A417 Missing Link DCO

Joint Councils Written Submission of case put orally at the Hearings held the week commencing 24 January 2022

Gloucestershire County Council, Cotswold District Council,
Tewkesbury Borough Council

2 February 2022

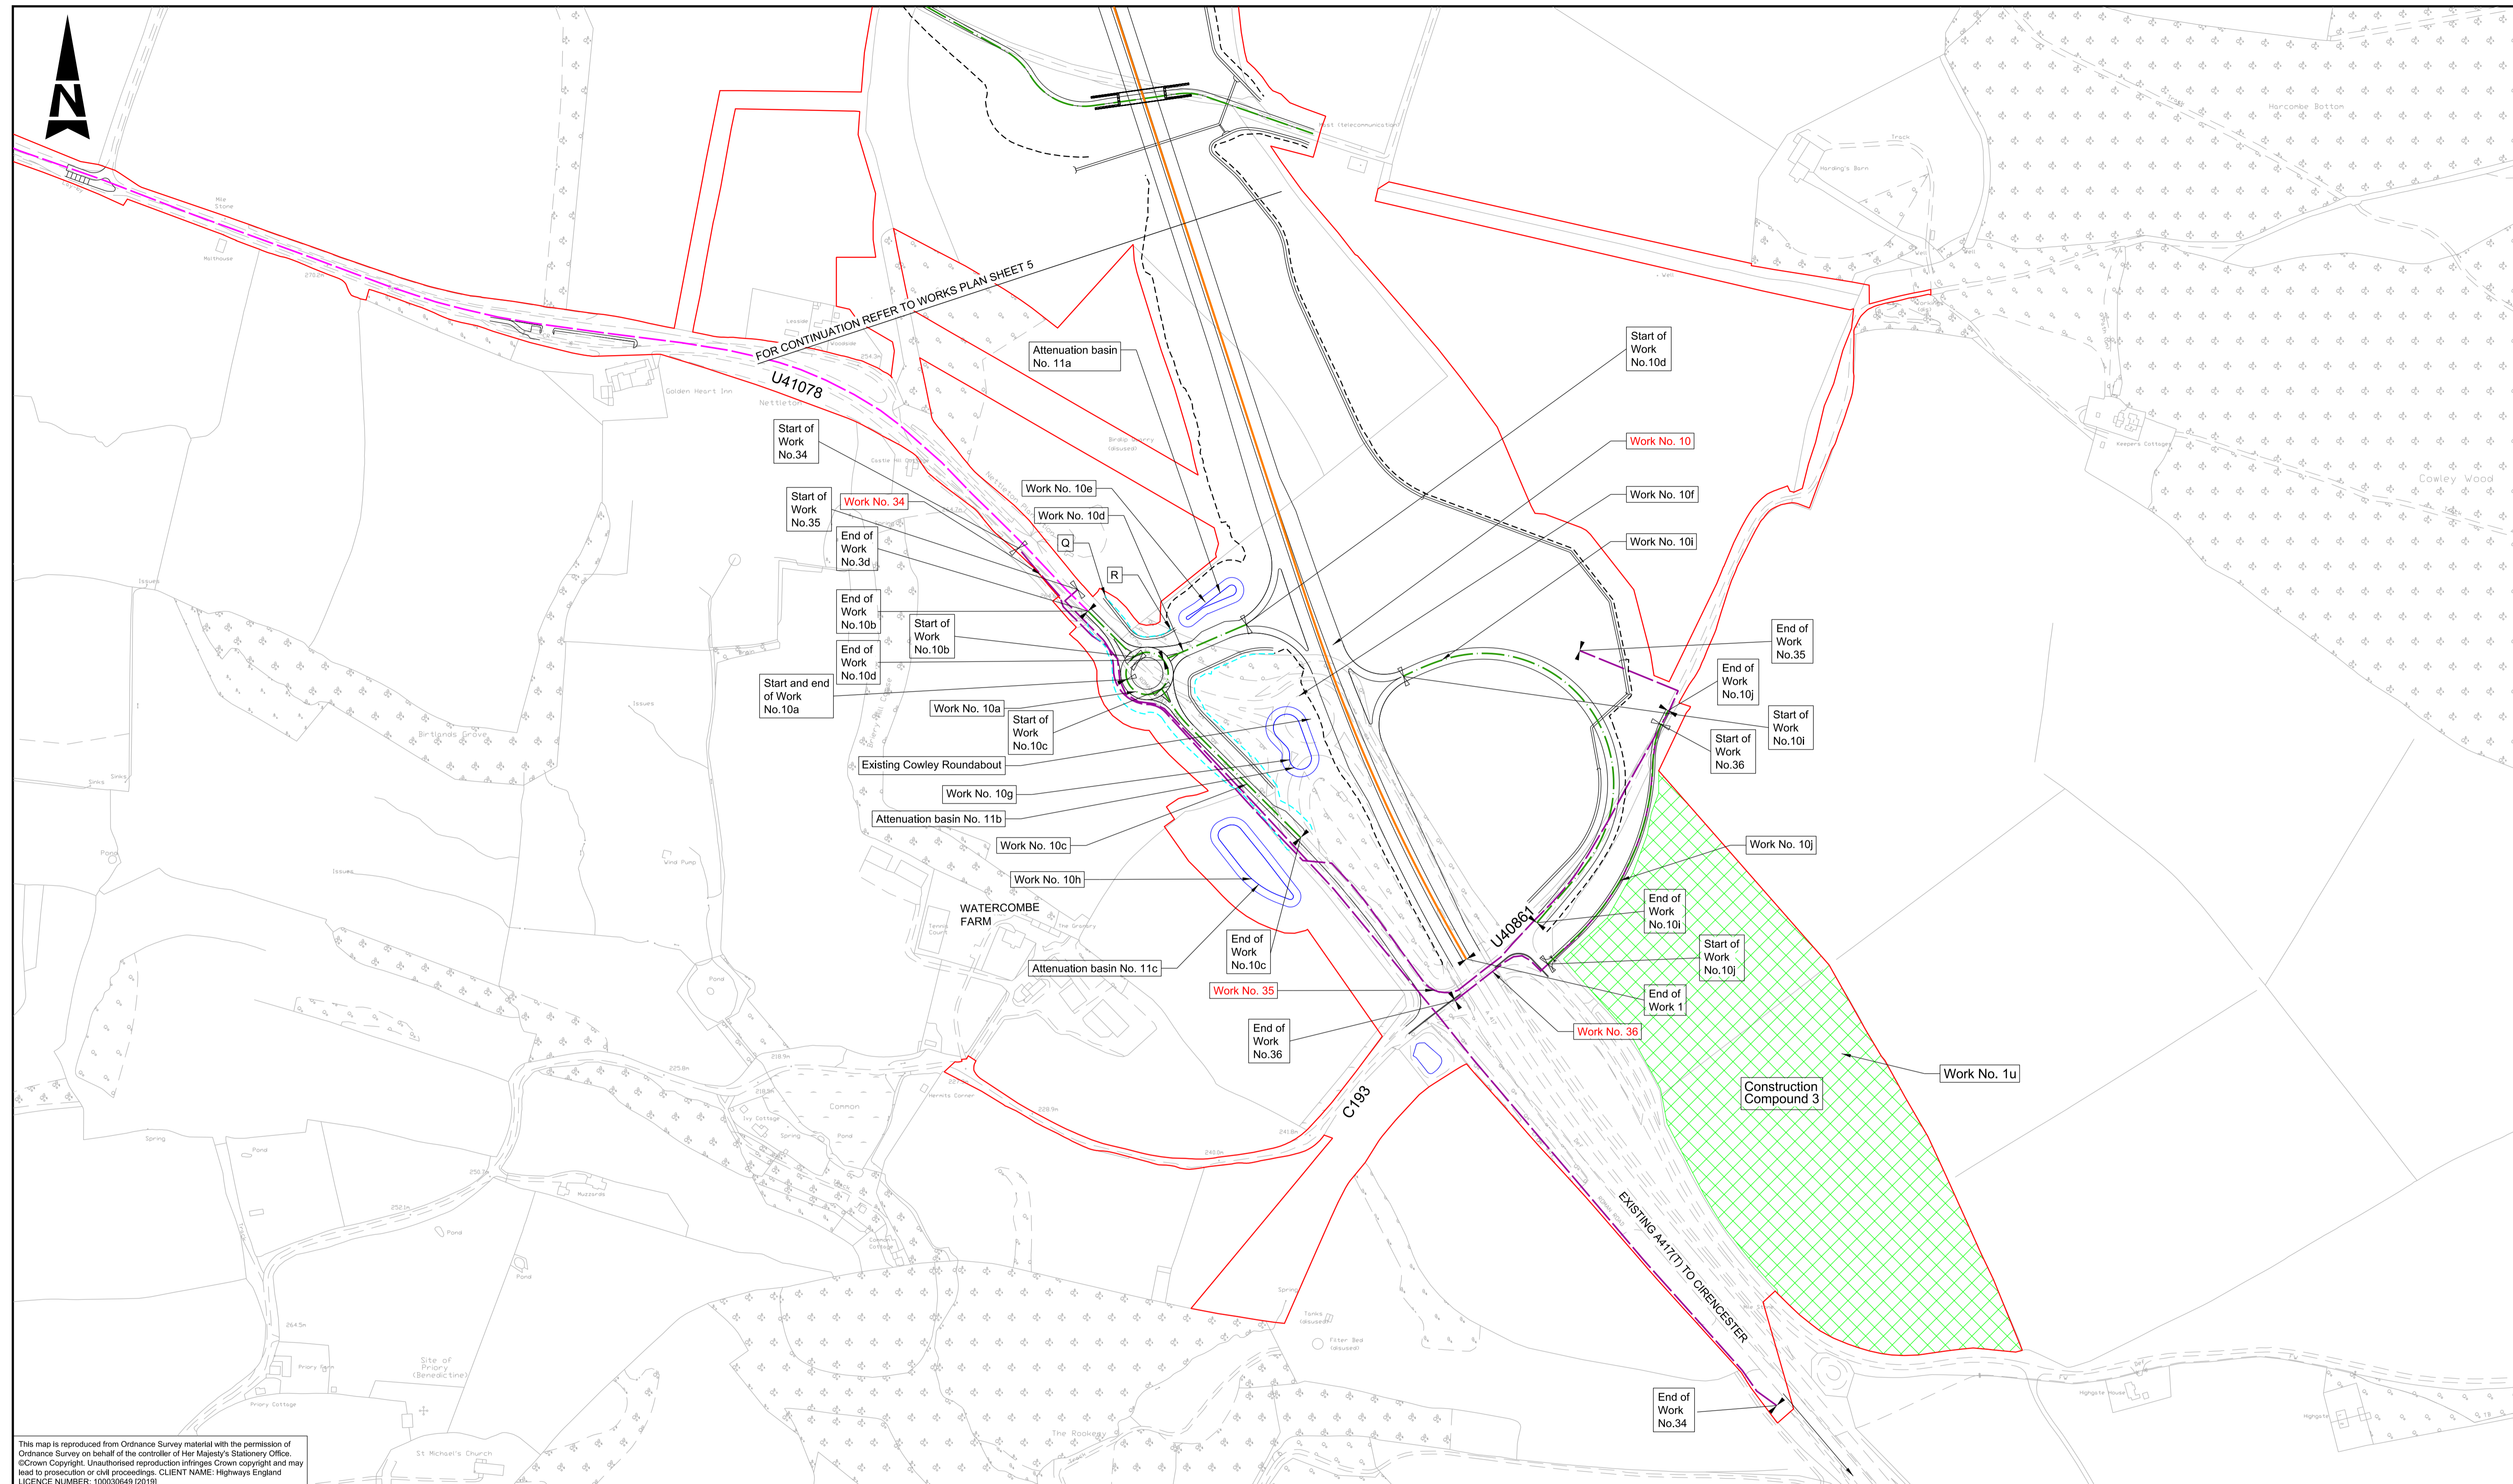
- There is a lack of preliminary design information for the proposed National Trail included on the general arrangement plans and works plans to be secured under Requirement 11 Detailed Design and a lack of design detail in the National Trail Diversion Report secured under Article 20.
